From: Sue Howell <Sue.Howell@arun.gov.uk>
Sent: 31 October 2019 14:50
To: Planning.Responses <Planning.Responses@arun.gov.uk>
Cc: Raymond Cole <Raymond.Cole@arun.gov.uk>
Subject: RE: Planning Consultation on: AL/72/19/PL

Comment from Greenspace

APPLICATION NO: AL/72/19/PL

Description of Works: Demolition of existing buildings & erection of 10 No. houses, comprising 1x three bedroom detached, 6x three bedroom semi detached & 3x four bedroom detached houses with associated access & parking (resubmission following AL/118/18/OUT).

Project	Land at Oak Tree Lane, Woodgate
Drawing	Tree Protection Plan
Date	14.08.19
Ref	18-668-TPP-B
Drawn	NT
Checked	DR
Client	Turnbull Land Ltd & Mr. J.C. Co
Scale	1:250@A3

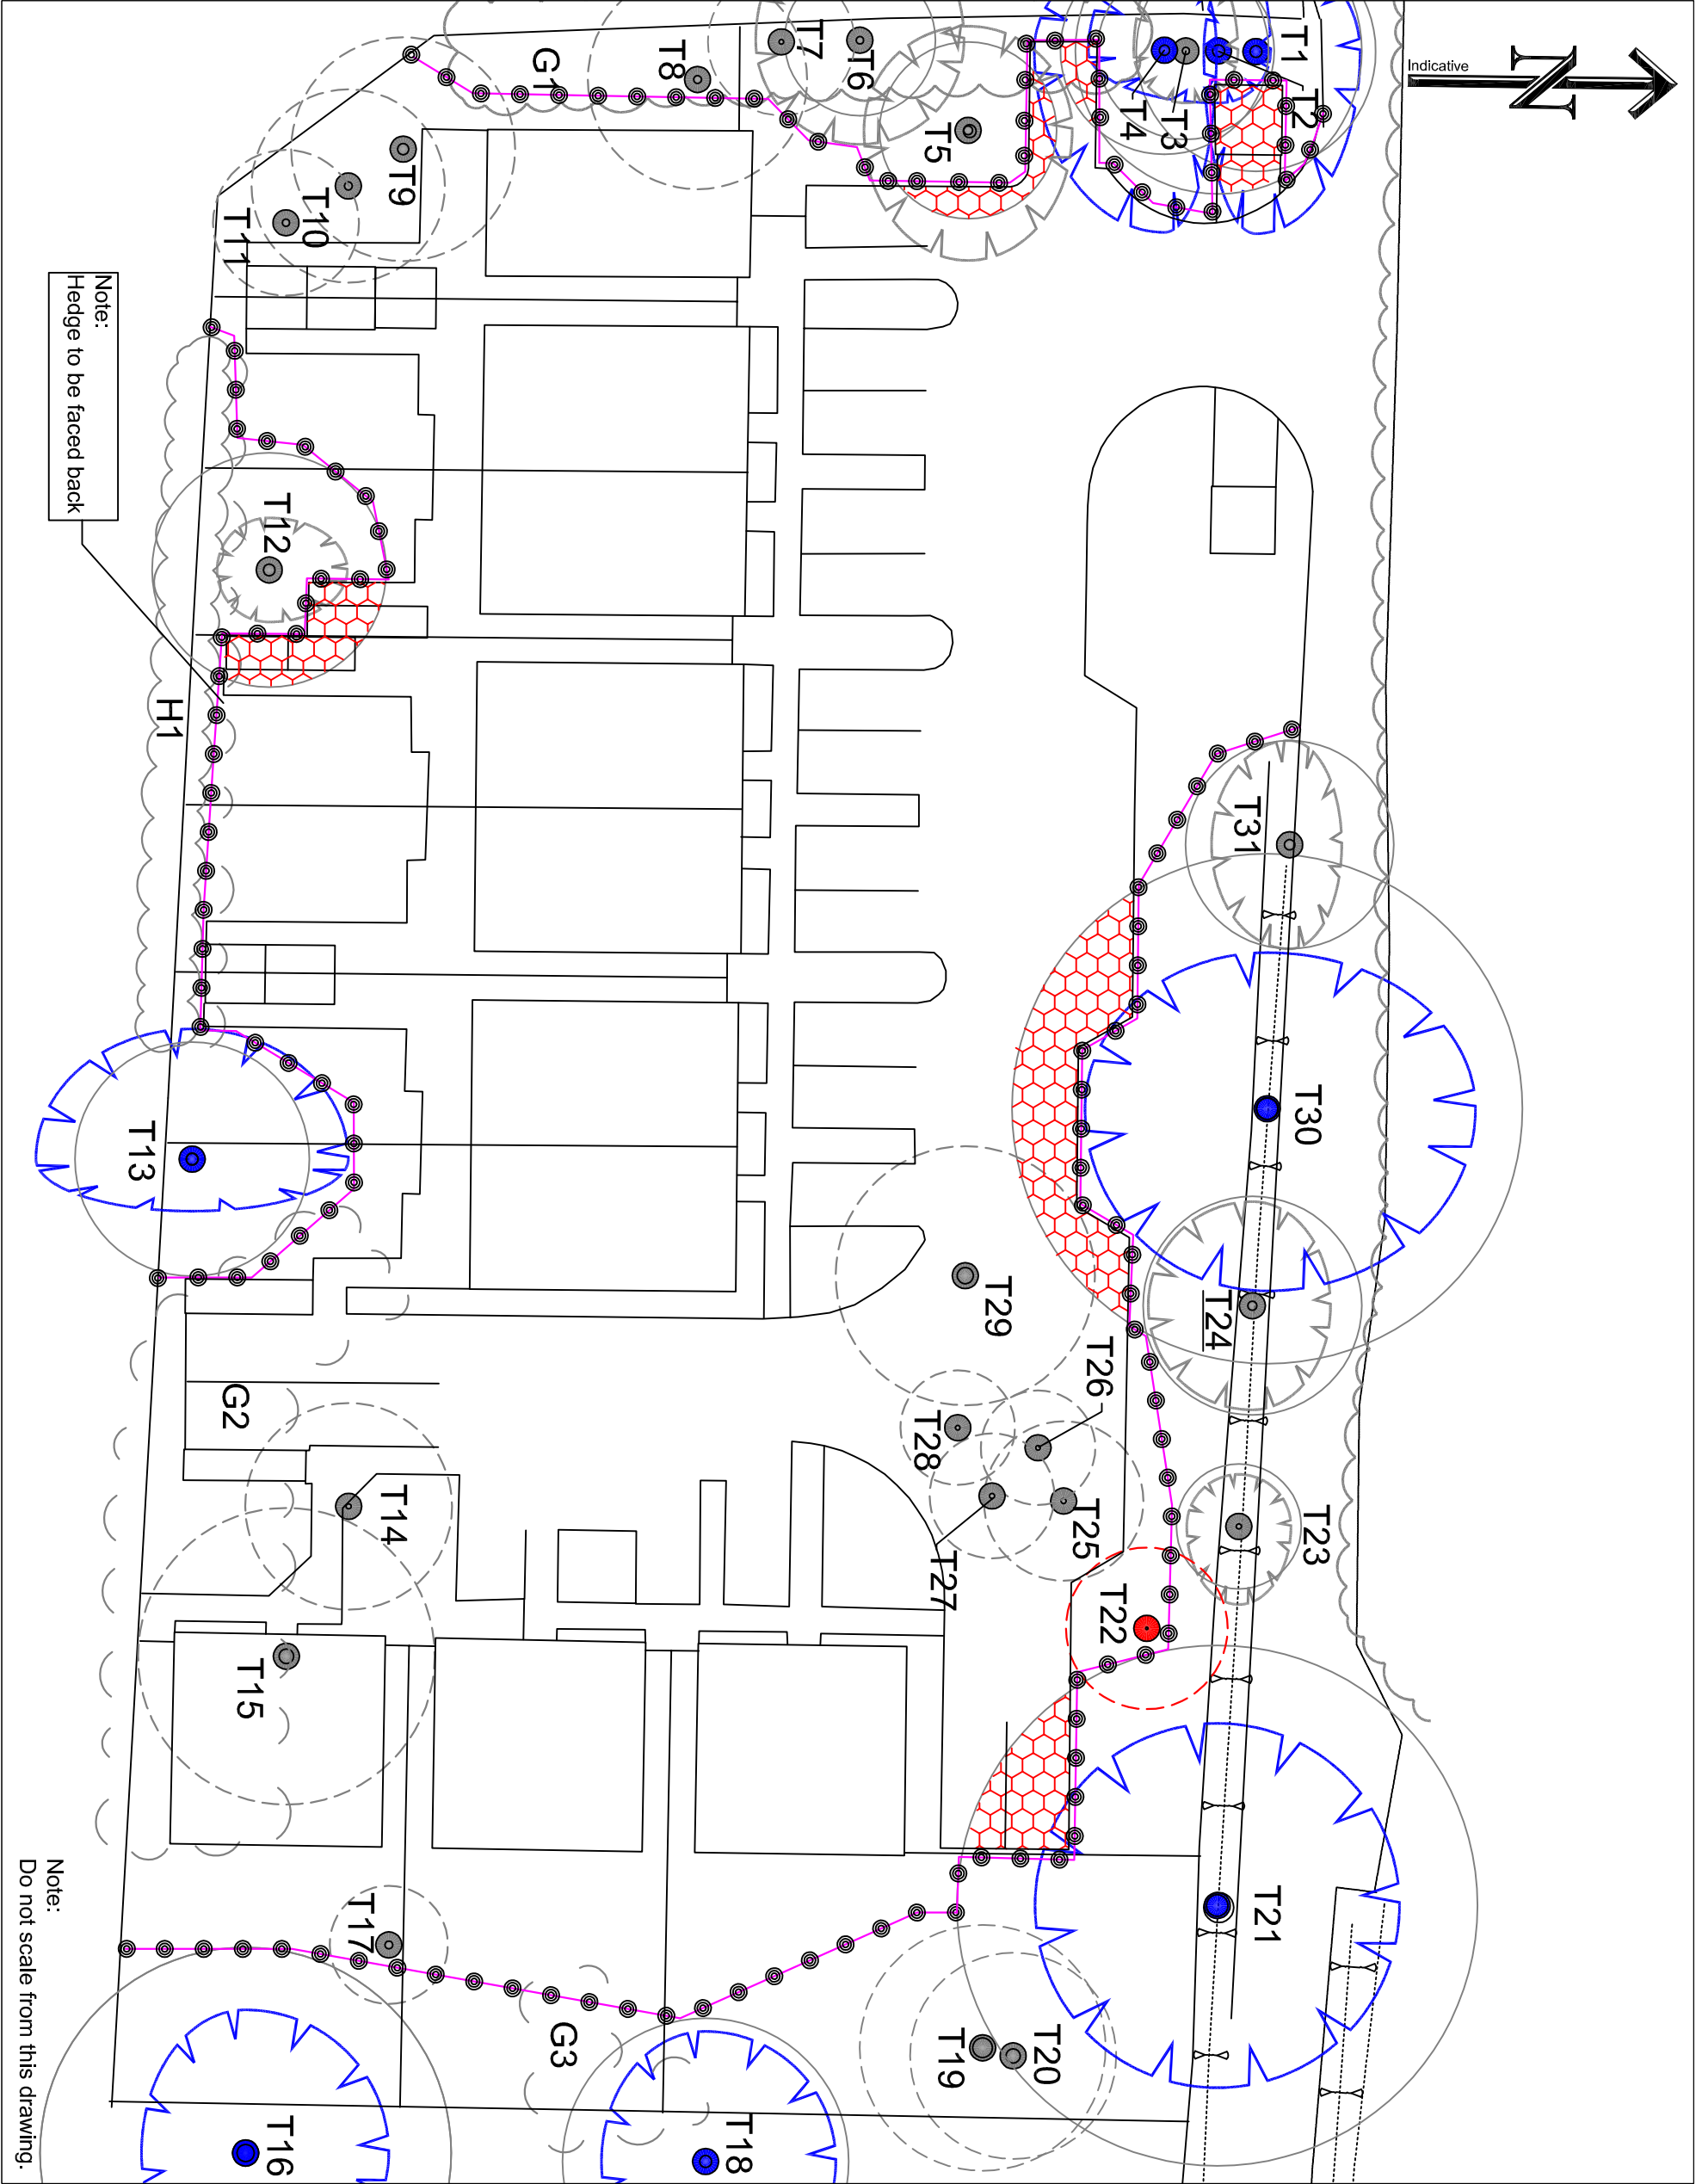
Any considered tree removal from this site should be agreed with Arun District Councils Tree Officer. Root protection Areas (RPA) should extend into the development site and to those in neighbouring land. Before construction, a tree protection scheme must be in place for any retained trees including trees whose root

protection areas fall within the construction zone from neighbouring land. Any agreed removed trees should be mitigated for allowing for inclusion of native species for biodiversity purposes and fitting to the semi-rural setting.

Tree protection fencing requirements identified and tree protection plans submitted would need to be conditioned with any permission.
